DECISION DELEGATED TO HEAD OF PLANNING

Application No: H09-0420-24 **Applicant:** Mr & Mrs Holmes
Proposal: Proposed Barn Conversion into Residential Dwelling
Location: 98 Dog Drove North Holbeach Drove Spalding
Terminal Date: 30th July 2024

Site Plan
Scale: 1:200

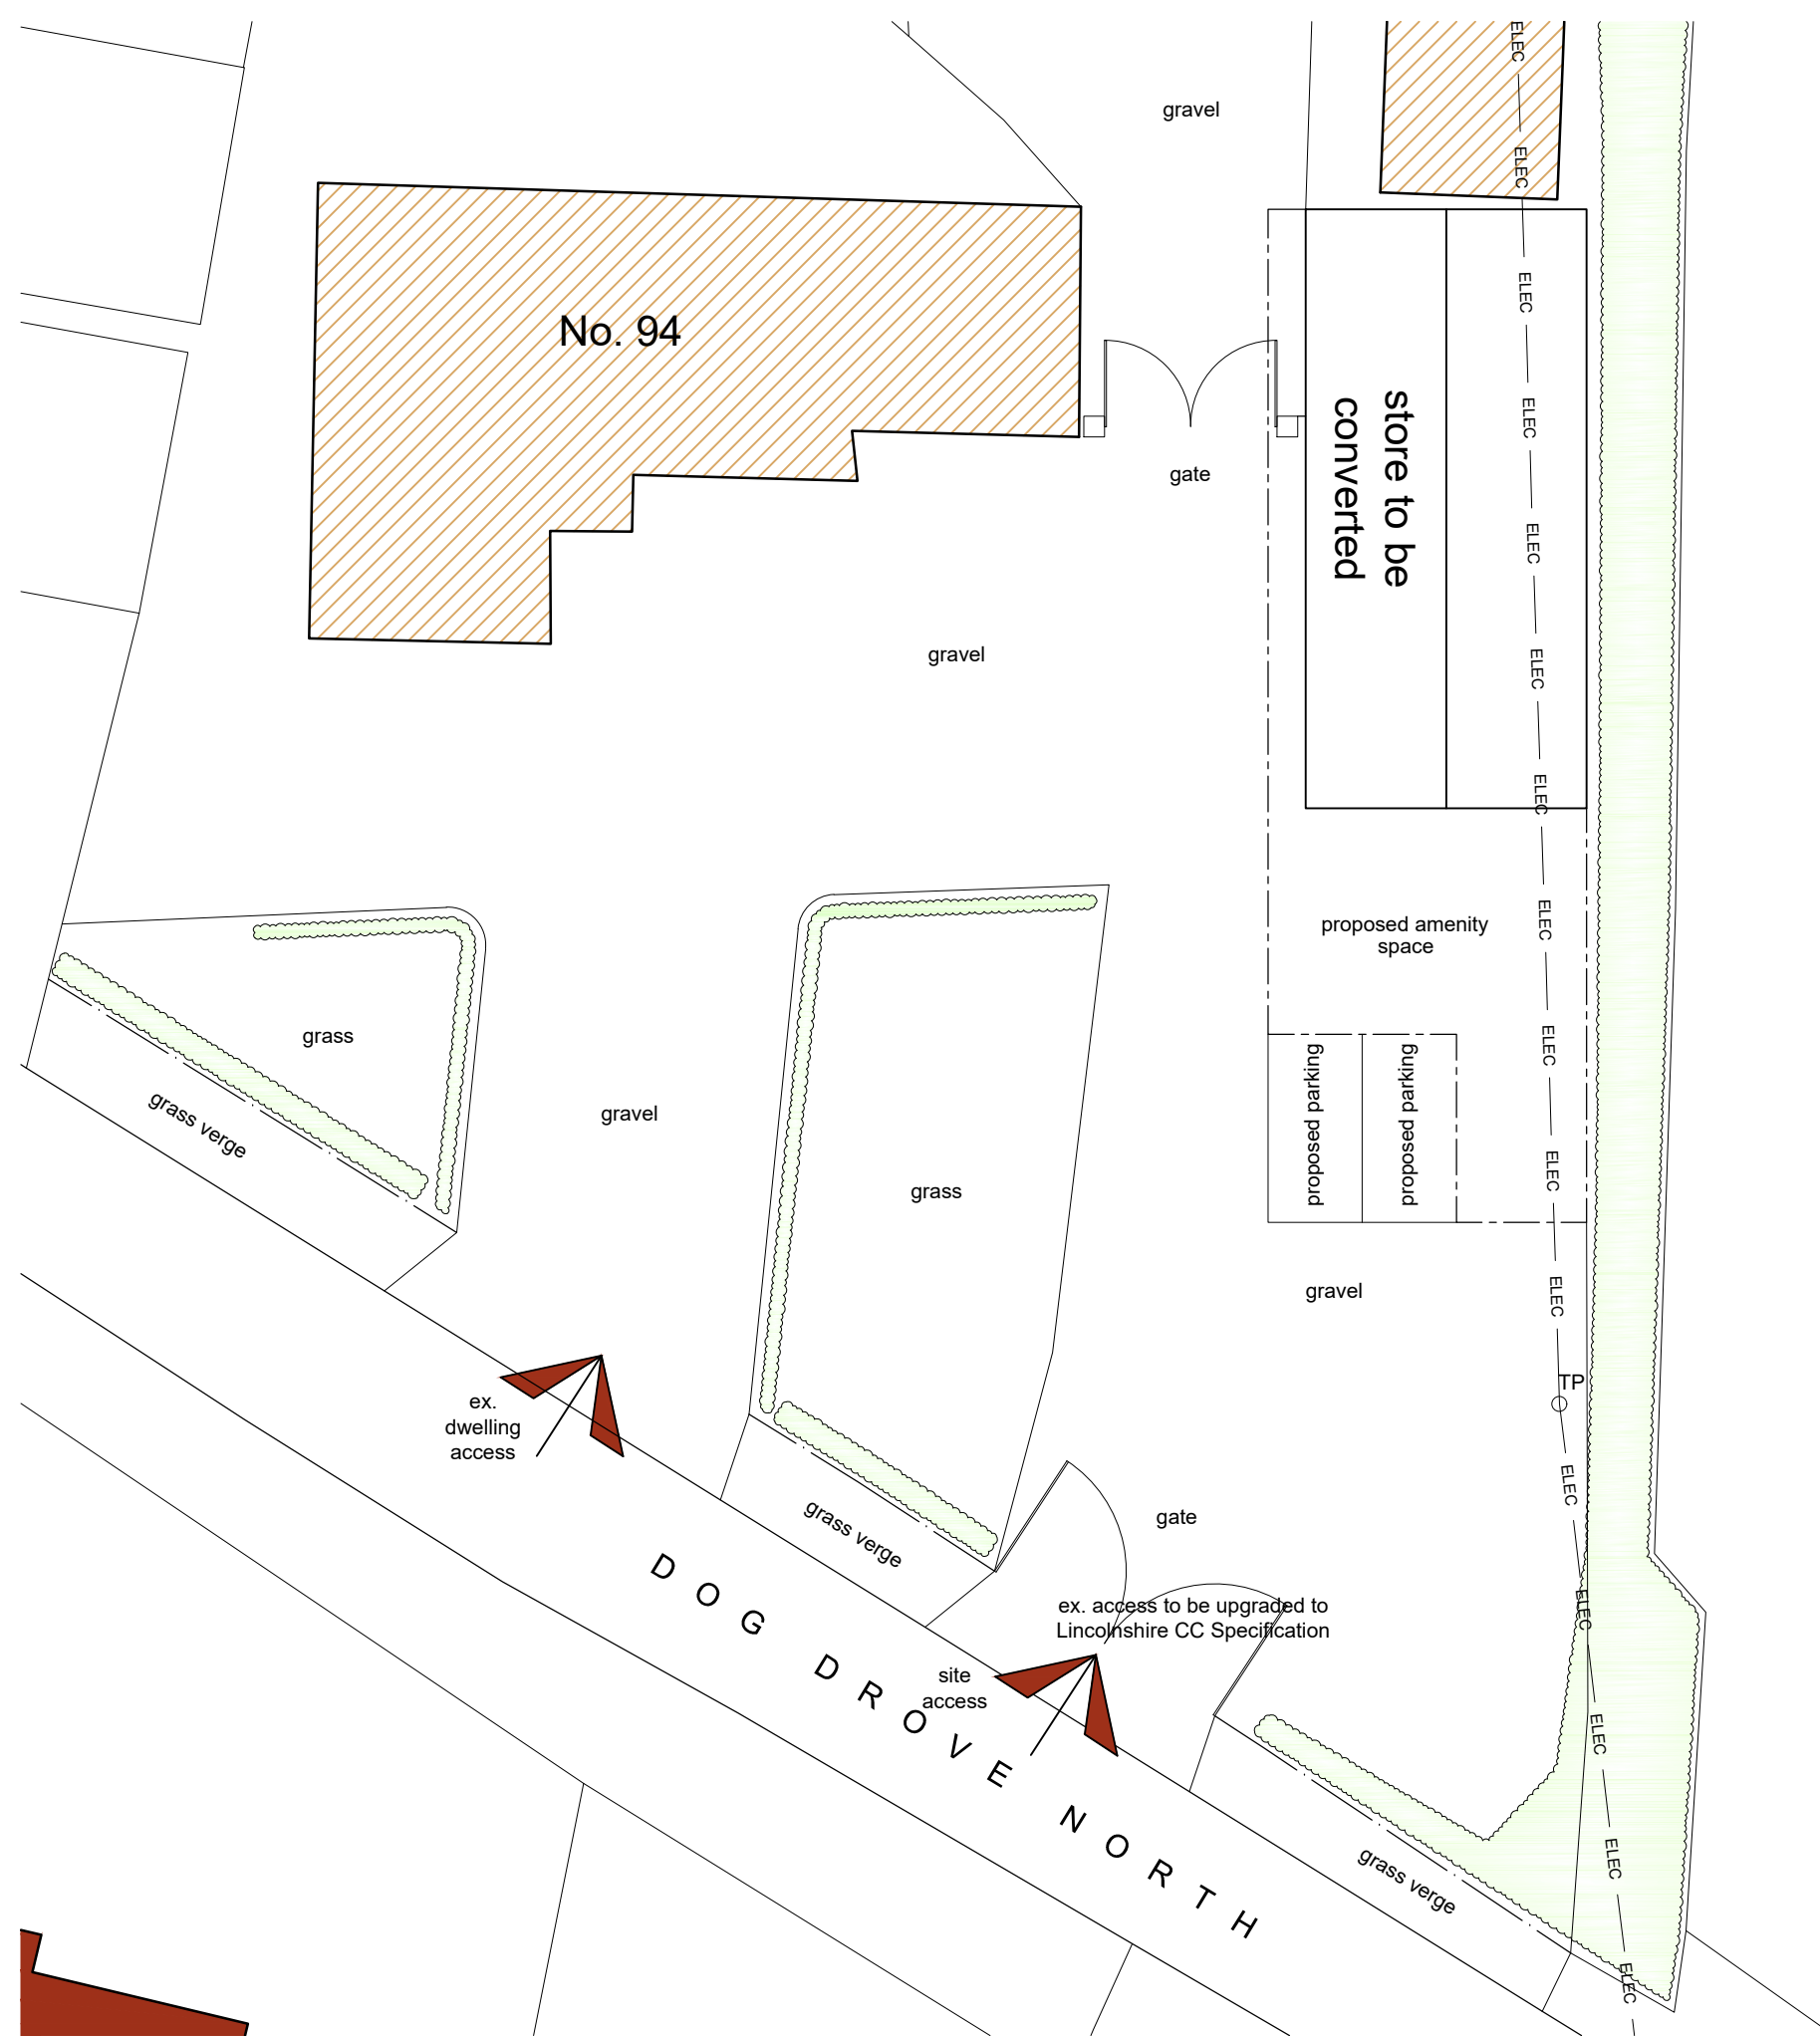
The Block plan shows the site access to be the access to the south whereas there is another access further north. What is the proposal for the northern access? Will the access for the barn be shared with the host dwelling using the southern access? Is it necessary to keep both access points? The access points should be upgraded to Lincolnshire County Council Specification. If any access is no longer required it should be formally stopped up."

"The application is for Prior Approval of a Barn Conversion into a Residential Dwelling. The conversion will be a 3-bed property, the parking and turning space is acceptable. There is a separate access for the host dwelling and the access to the north will be for the conversion. This access will be upgraded to Lincolnshire County Council Specification as per the proposed block plan. The proposal will not have an adverse impact on the public highway. As Lead Local Flood Authority, Lincolnshire County Council is required to provide a statutory planning consultation response with regard to drainage and surface water flood risk on all Major applications. This application is classified as a Minor Application and it is therefore the duty of the Local Planning Authority to consider the surface water flood risk and drainage proposals for this planning application."

(a) Transport/Highways - The proposal is for the change of use of an agricultural barn to one dwelling, with use of an existing access off Dog Drove North. The access is separate to that used by 98 Dog Drove. The Local Highway Authority has raised no objection to this arrangement. It is not considered that the proposal would significantly impact highway safety or traffic in the area.
